**Comment Letter for Proposed Redevelopment of 6950 SE Maker Street, Permit 2207-019**

My name is Dan Grove and I live at 3515 72nd Ave SE. I'm writing as a concerned neighbor who shares a property boundary with the proposed development (submission documents [here](#)) at 6950 Maker Street ("The Project", owned by The Strand Trust). As a long-time member of the Mercer Island community, I was surprised and dismayed to see a proposal for a house much larger than permitted by code, a house built to a height of 34+' on top of an artificially elevated lot, a house that would be built on a lot with a history of rockery problems and a house whose development was enabled by significantly damaging an exceptional tree. That this proposal was submitted without any discussion with neighbors of the property makes it even more troubling.

MERCER RESIDENCE  
6950 SE MAKER ST MERCER ISLAND, WA

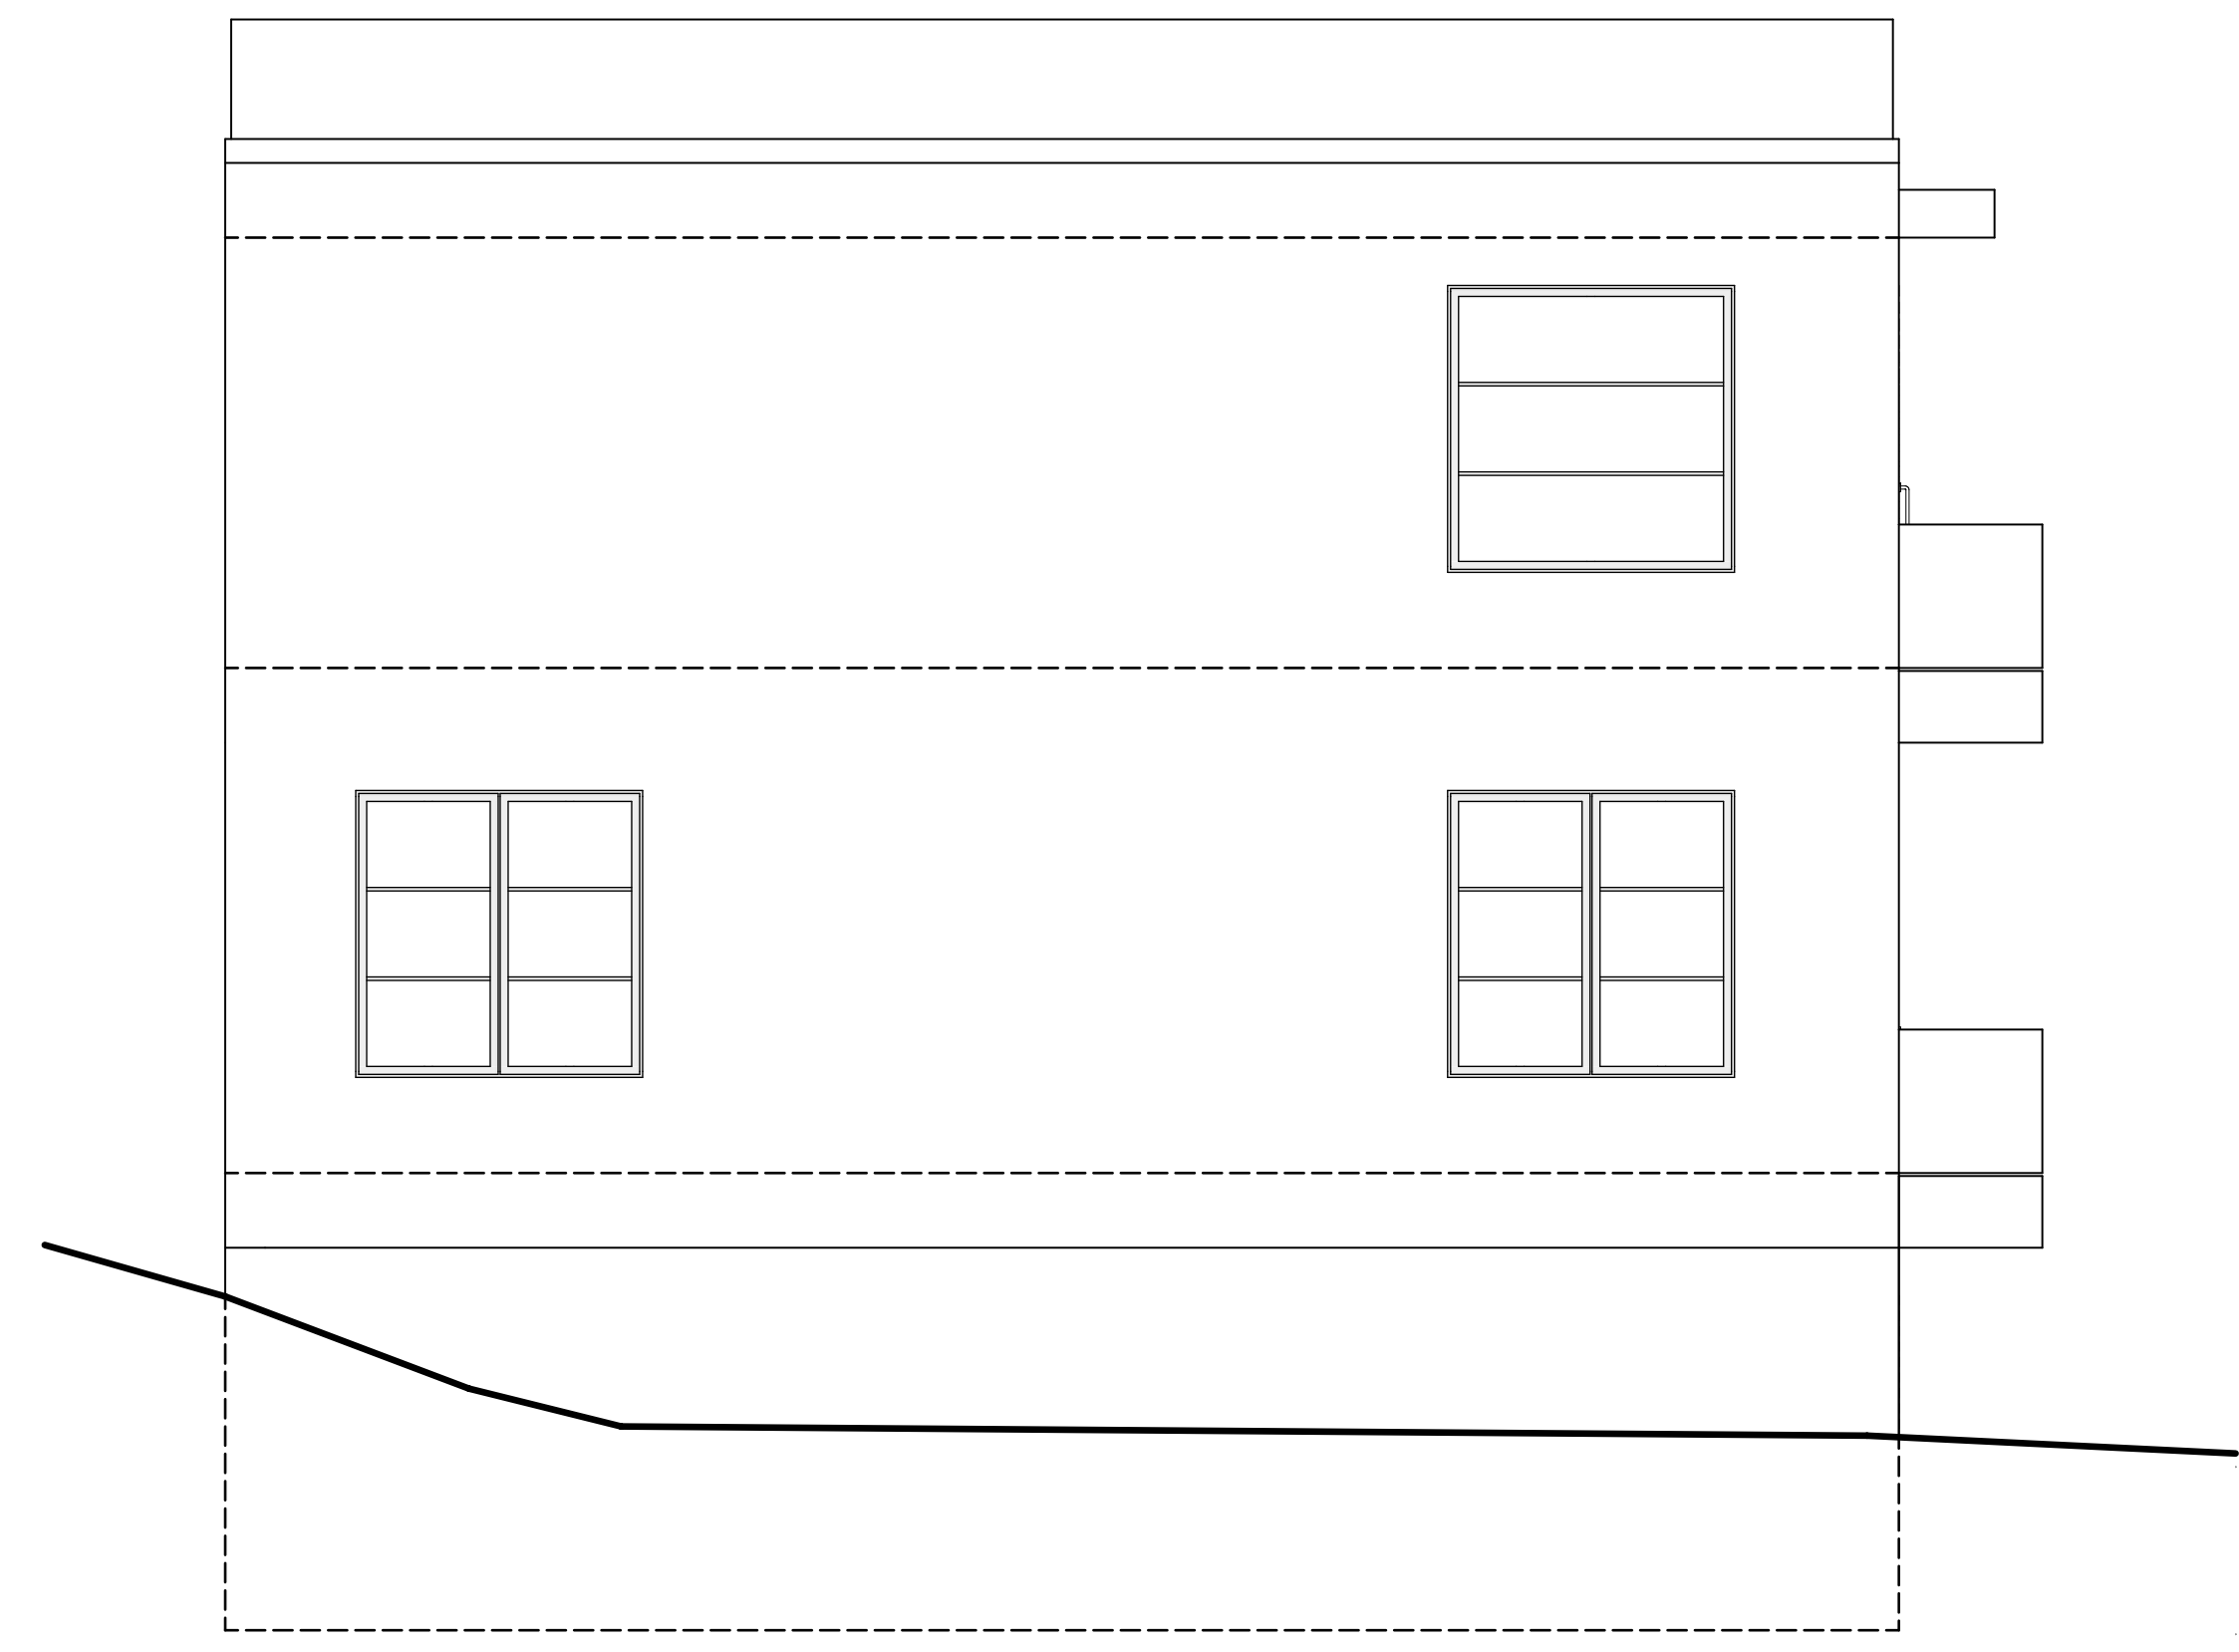
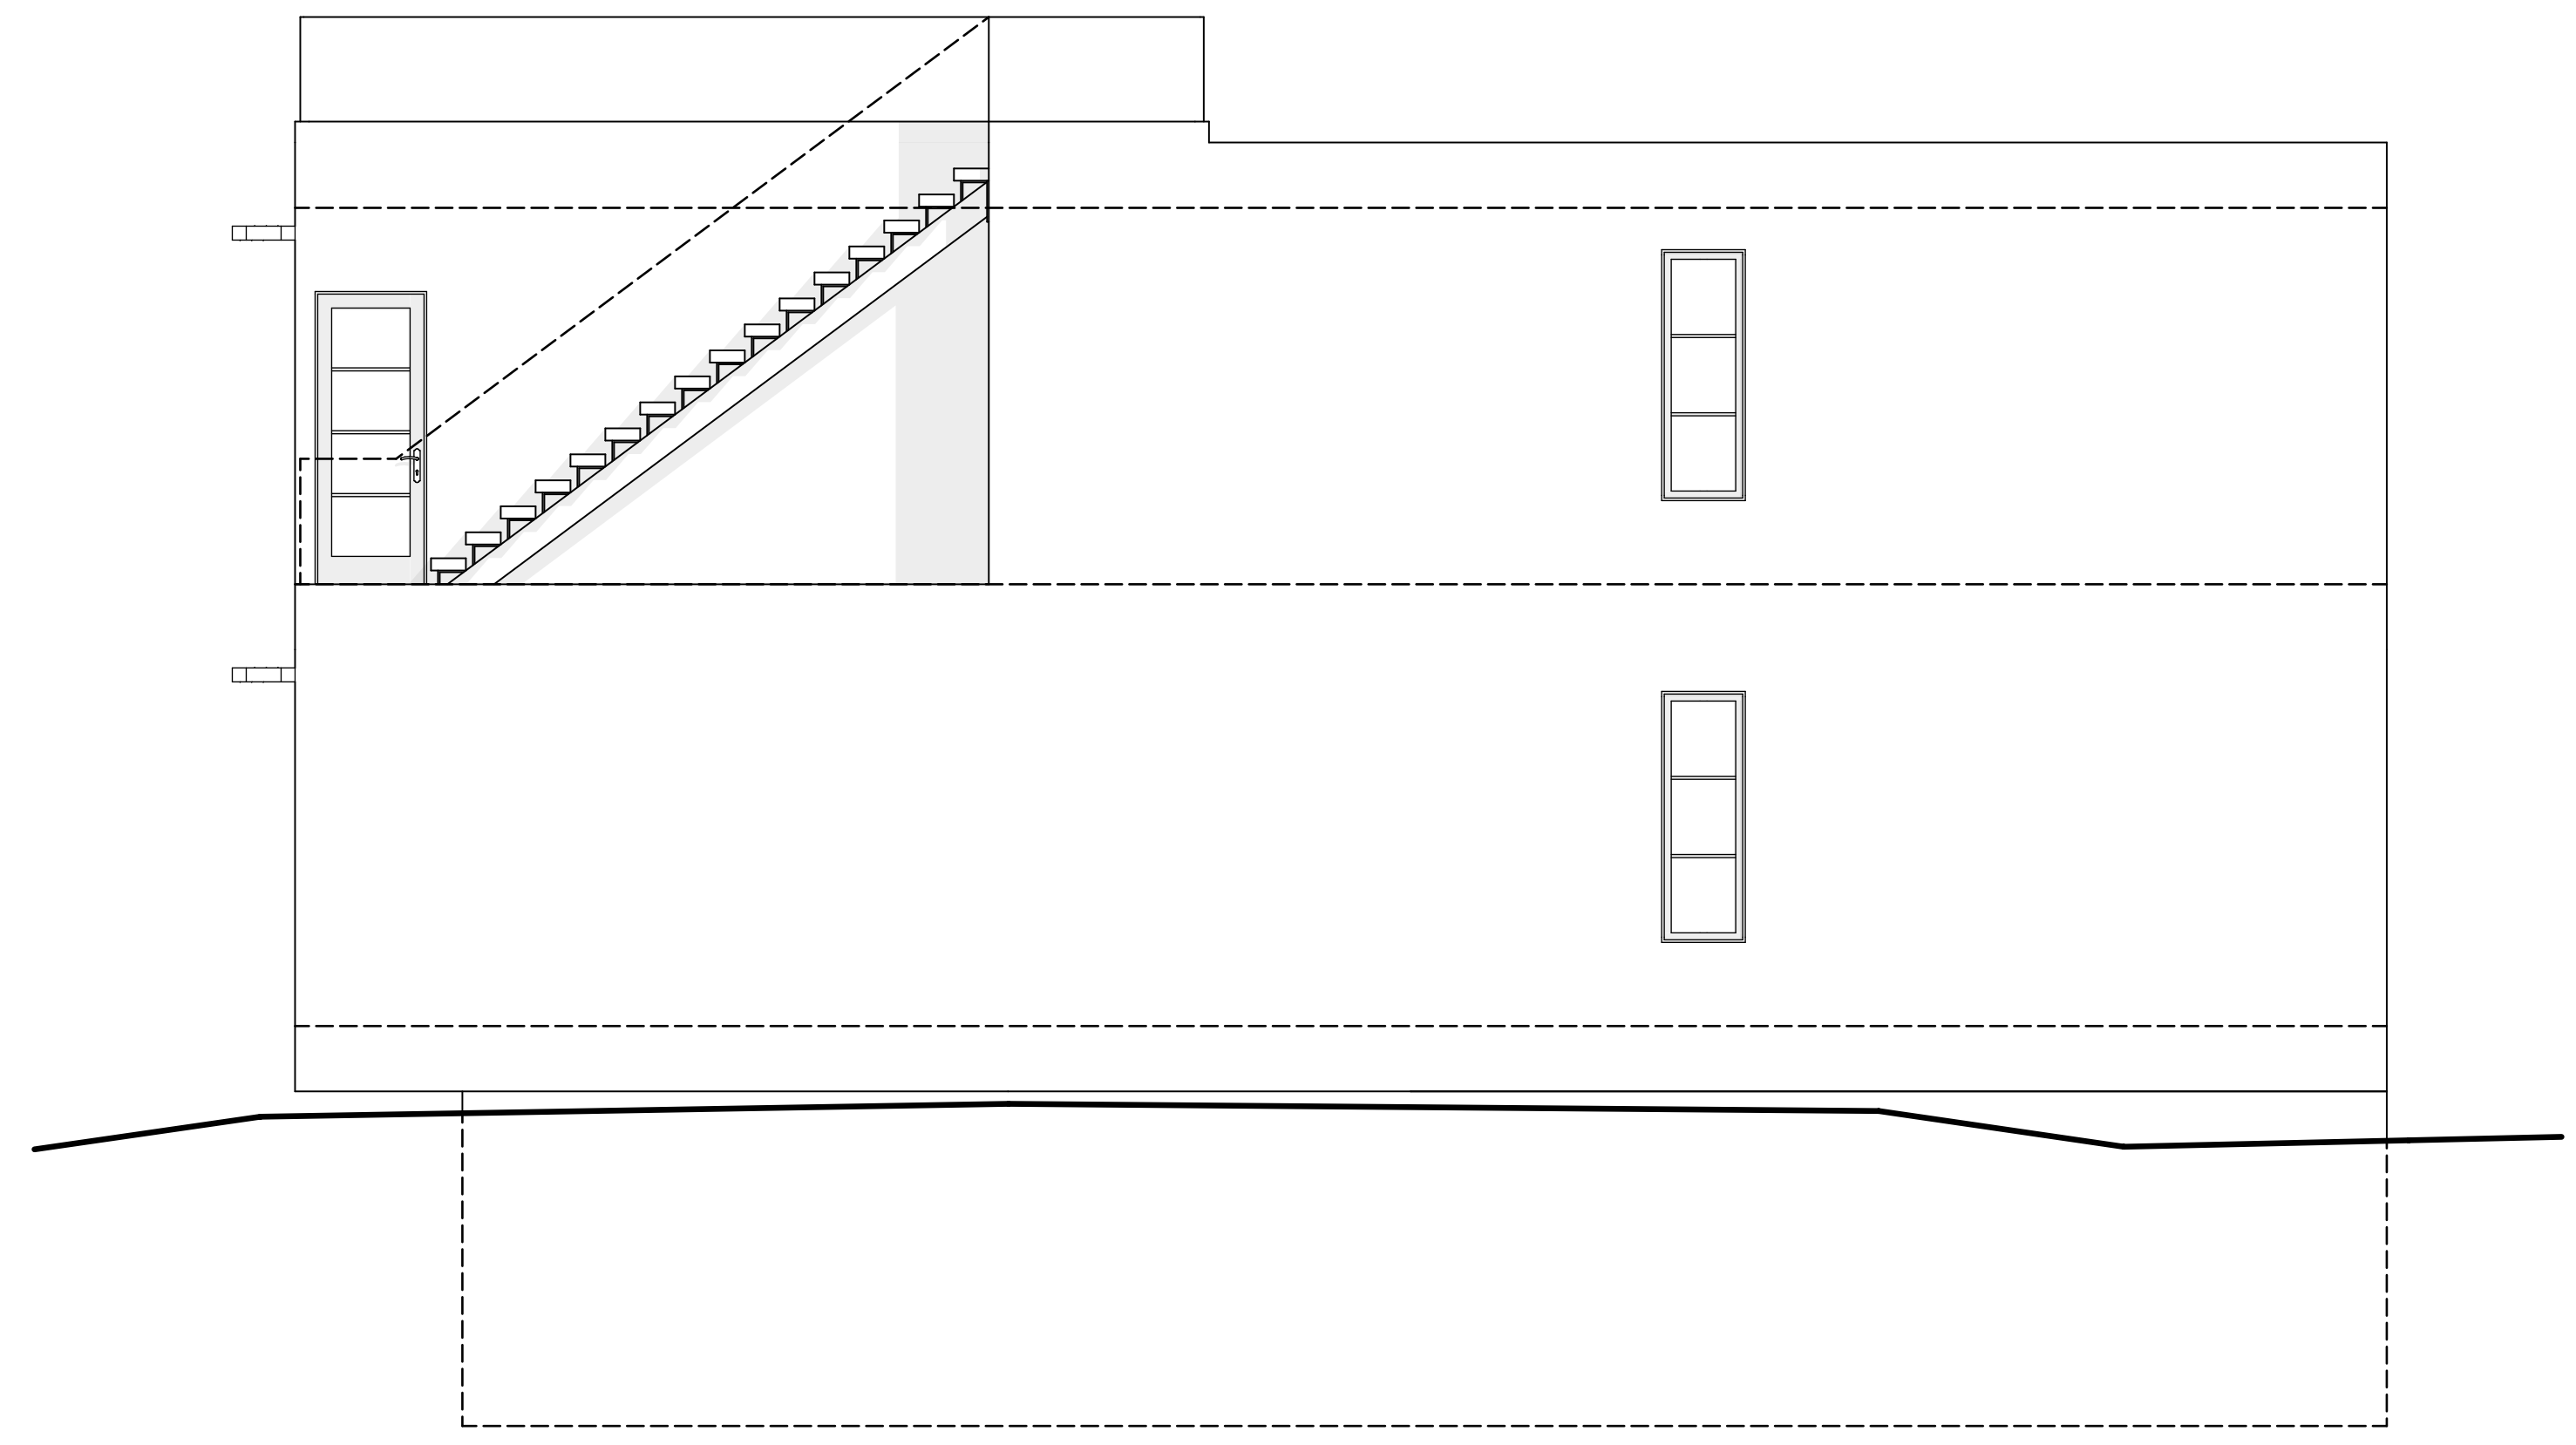
Consequently, the applicant incorrectly computes the Average Building Elevation<sup>2</sup> ("ABE") as 233.06.' My data offers multiple forms of evidence that the correct ABE is approximately 226.7'.

- Because Average Building Elevation is computed incorrectly, The Project exceeds the maximum building height by more than 4'.
- Because Existing Grade is computed incorrectly, The Project exceeds the Maximum Building Height on a Downhill Slope by more than 8'.
- Because The Project's Gross Floor Area ("GFA") incorrectly excludes the entire basement (indeed, the entire lower level), The Project exceeds its maximum GFA by more than 1200 square feet (beyond the 3500 square feet allowed).
